City of Portland, Maine - Building or Use Permit Application
389 Congress Street, 04101 Tel: (207) 874-8703, Fax: (207) 874-8716

Permit No: 04-1125
Issue Date: 08/09/2004
CBL: 087 1005001

Location of Construction: 44 Church Ave
Owner Name: Wood Alfred S &
Owner Address: 131 Central Ave
CITY OF PORTLAND
Phone: 776-2264

Proposed Project Description:
add two rooms as second floor
19'8" x 13'4" & 10'6" x 12'
Per access record
Signature: JMB 9/8/04
Date: 9/8/04
PEDESTRIAN ACTIVITIES DISTRICT (P.A.D.)
Action: Approved Approved w/Conditions Denied

PRELIMINARY MINOR SITE PLAN

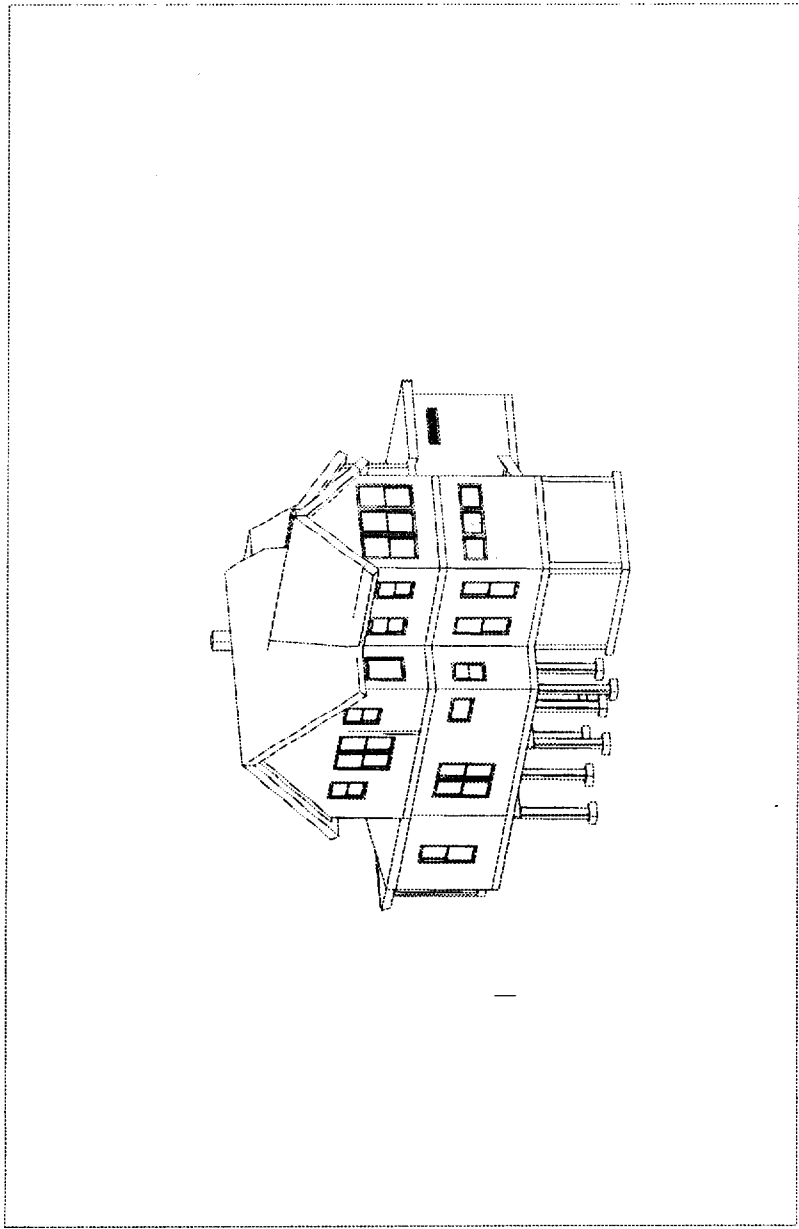
Dept: Zoning	Status: Approved with Conditions	Reviewer: Jeanine Bourke	Approval Date: 08/30/2004
Note: 8/26/04 left vm w/Alfred W. To call for clarification of plans. 8/30 A. Wood called to clarify new steps off shed			Ok to Issue: <input checked="" type="checkbox"/>
<ol style="list-style-type: none"> 1) Approved using Sec. 14-425 to allow an entrance porch into the rear setback up to 30 sf & not to exceed 6' into the setback 2) This property shall remain a single family dwelling. Any change of use shall require a separate permit application for review and approval. 3) Approved using Sec. 14-385 to re-build the 11' x 12' shed in the existing footprint. 4) Approved using Sec. 14-436(a) for a 50% expansion of the first floor footprint. This expansion is 28%, future expansions may only allow 22%.

IR-2 Zone
Edge of steps can be
no more than 10' from
The corner of house

*IR-2
Sec. 14-425
Entrance porch
allowed set
back of less
than
9 Maximum of 6'
in to Rear setback*

*Sec. 14-385 allows to
re-build shed in exact
Footprint*

Revised to show shed
step location

Wienske Wood
Foundation Plan
44 church Street
Peake Island, ME
Scale 1/4"=1'-0"

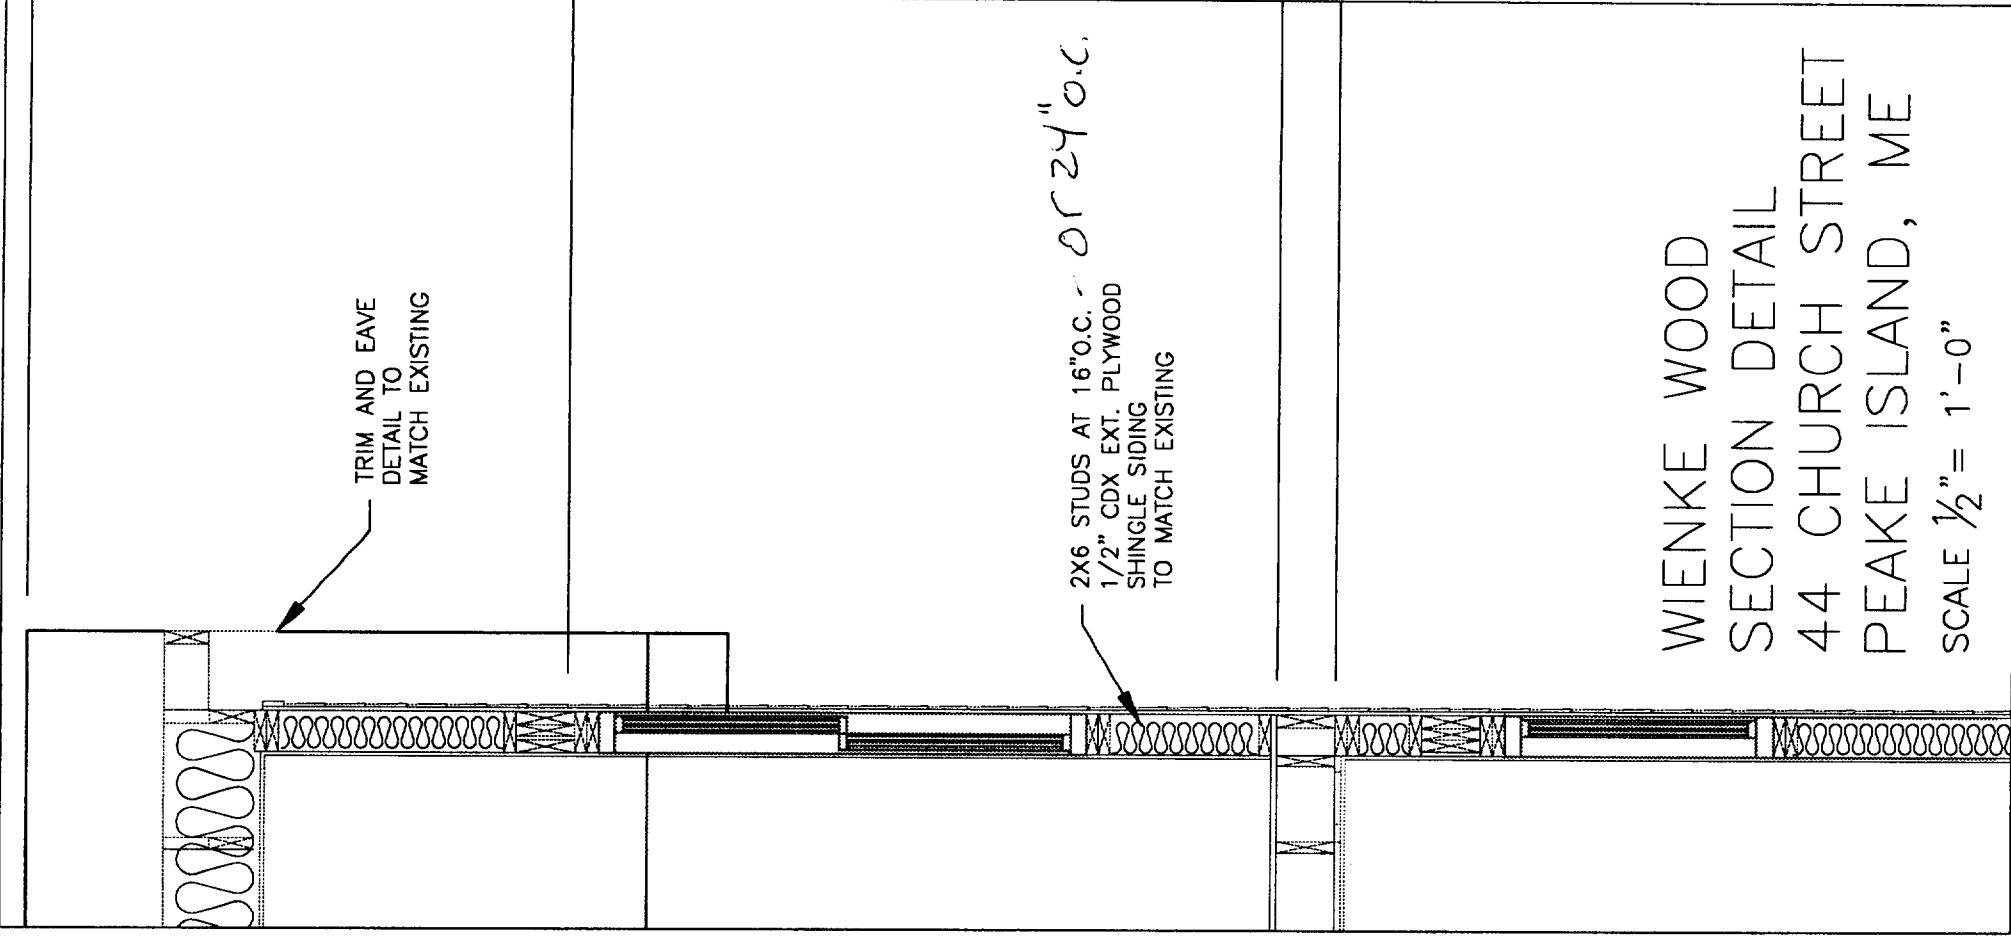
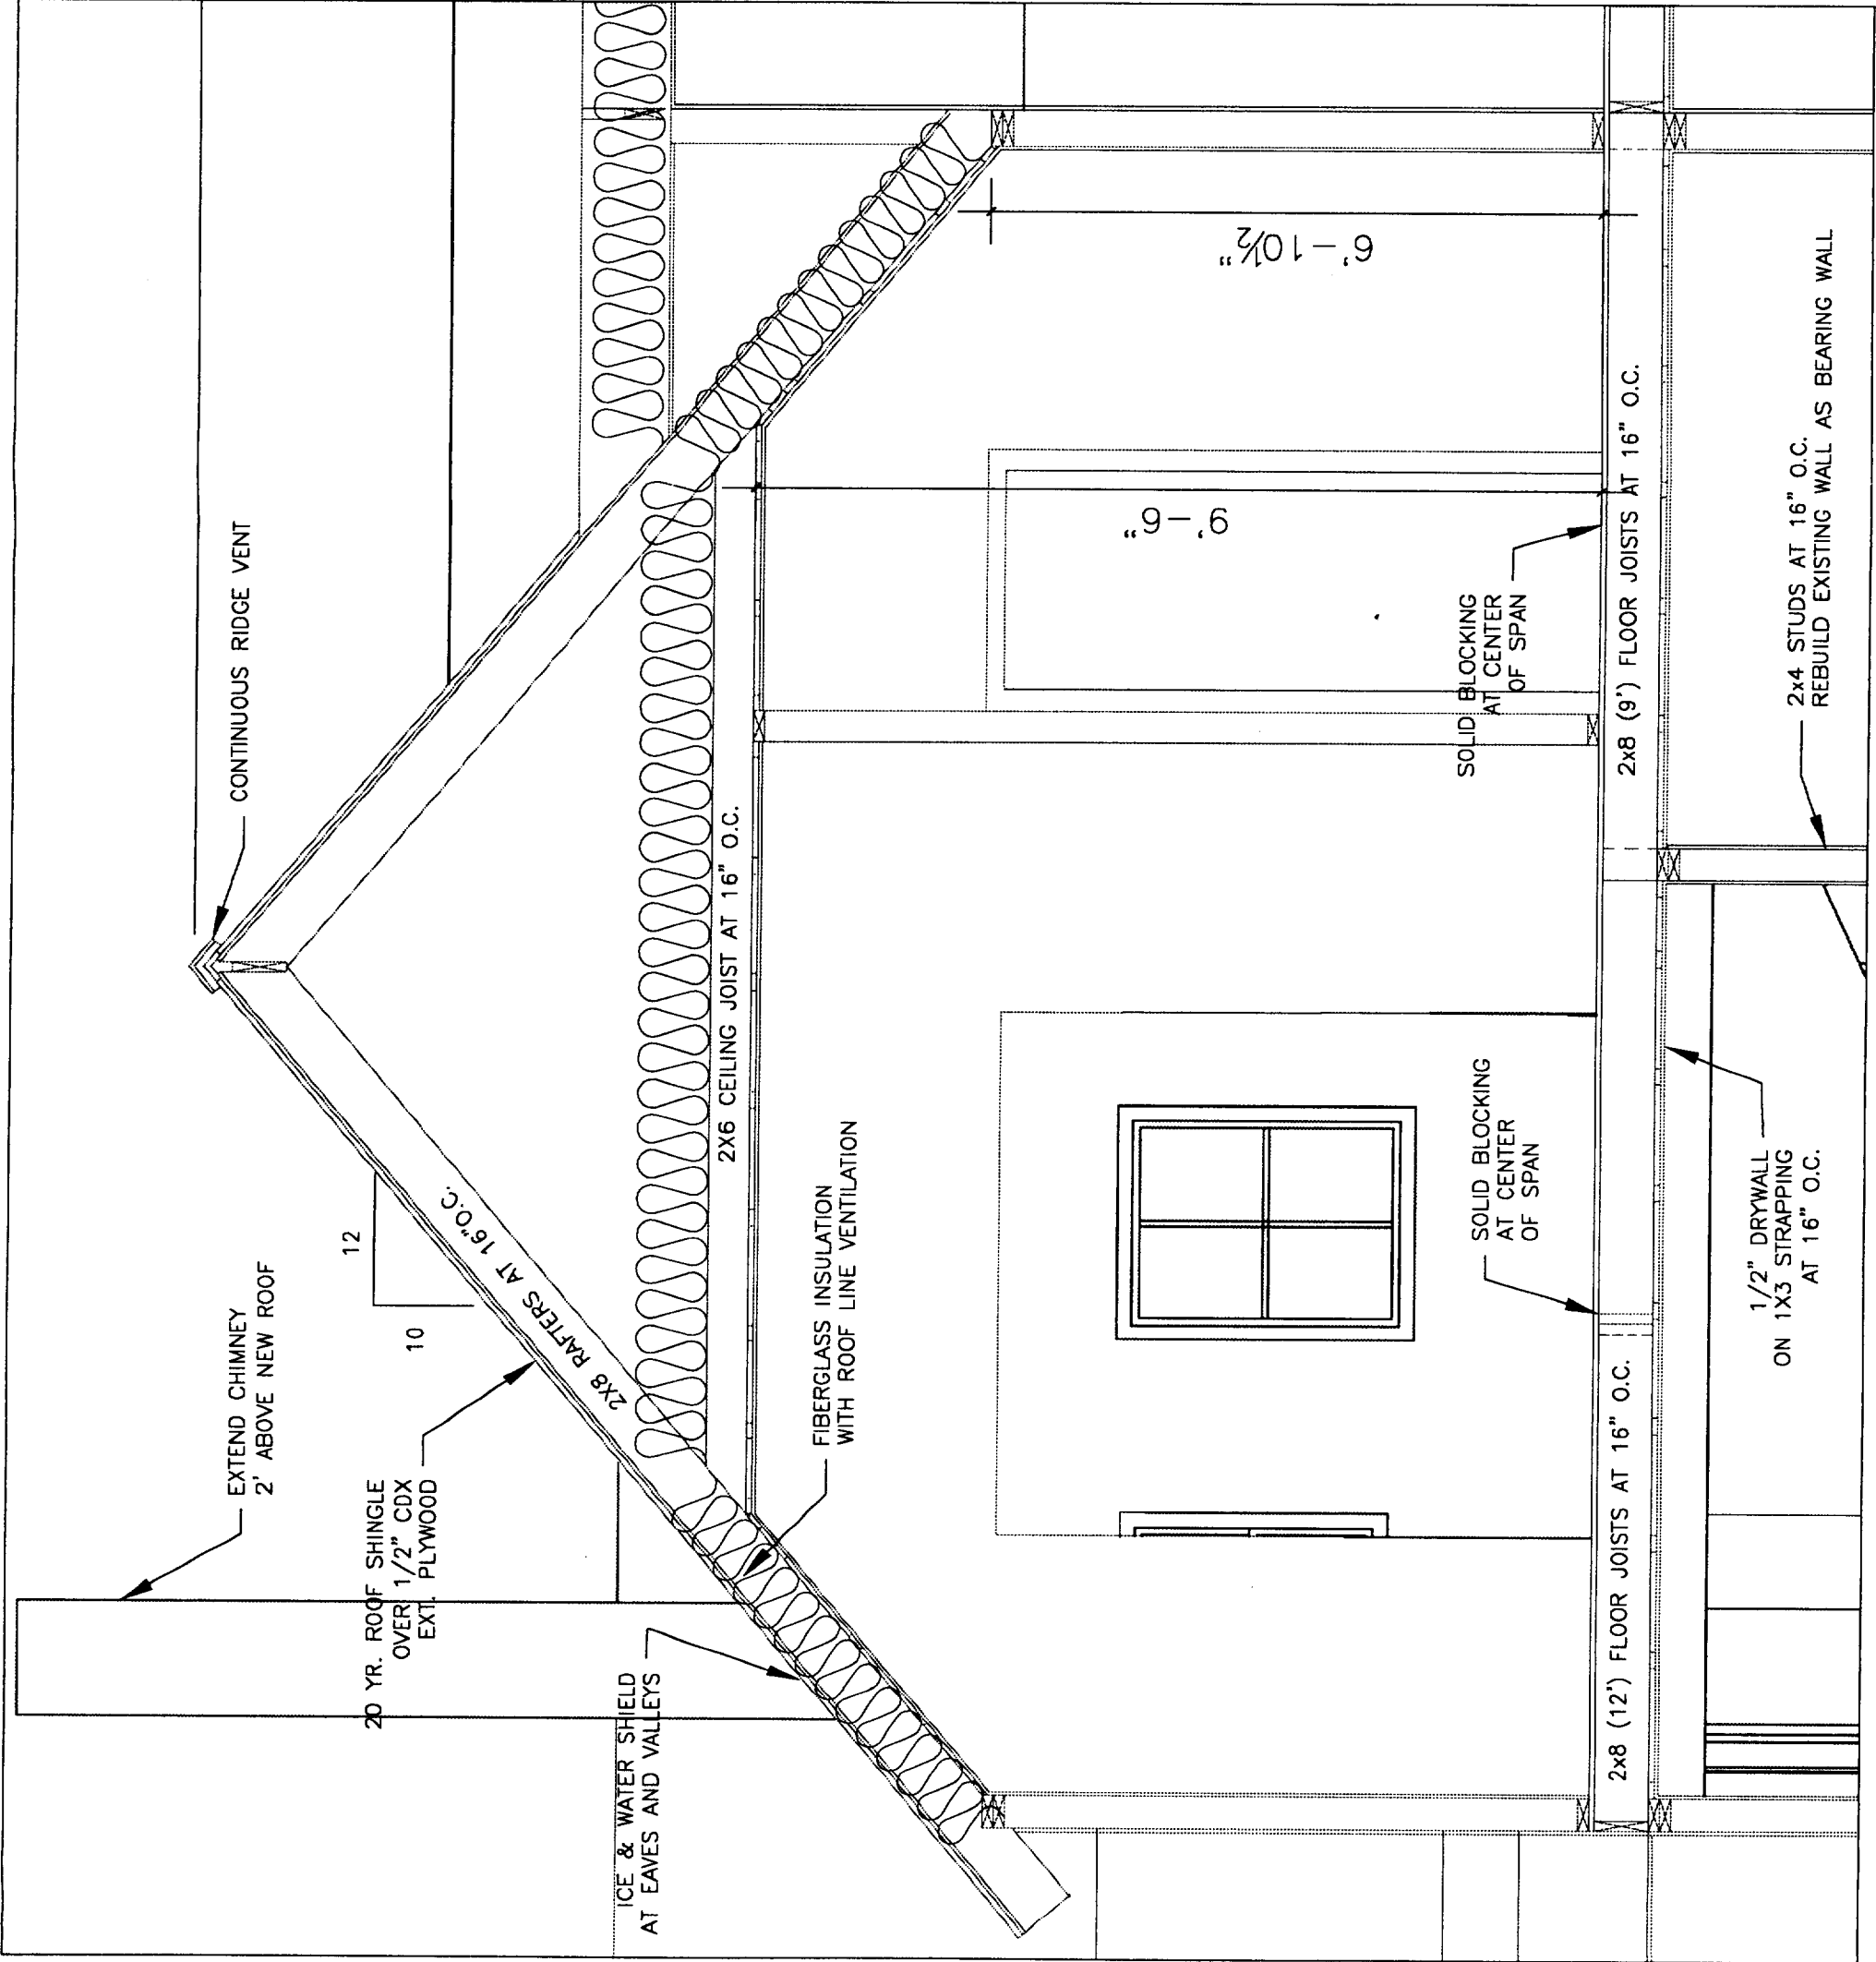
8 Canspan 5 1/4" OK

vents per A-wood 8/30/04
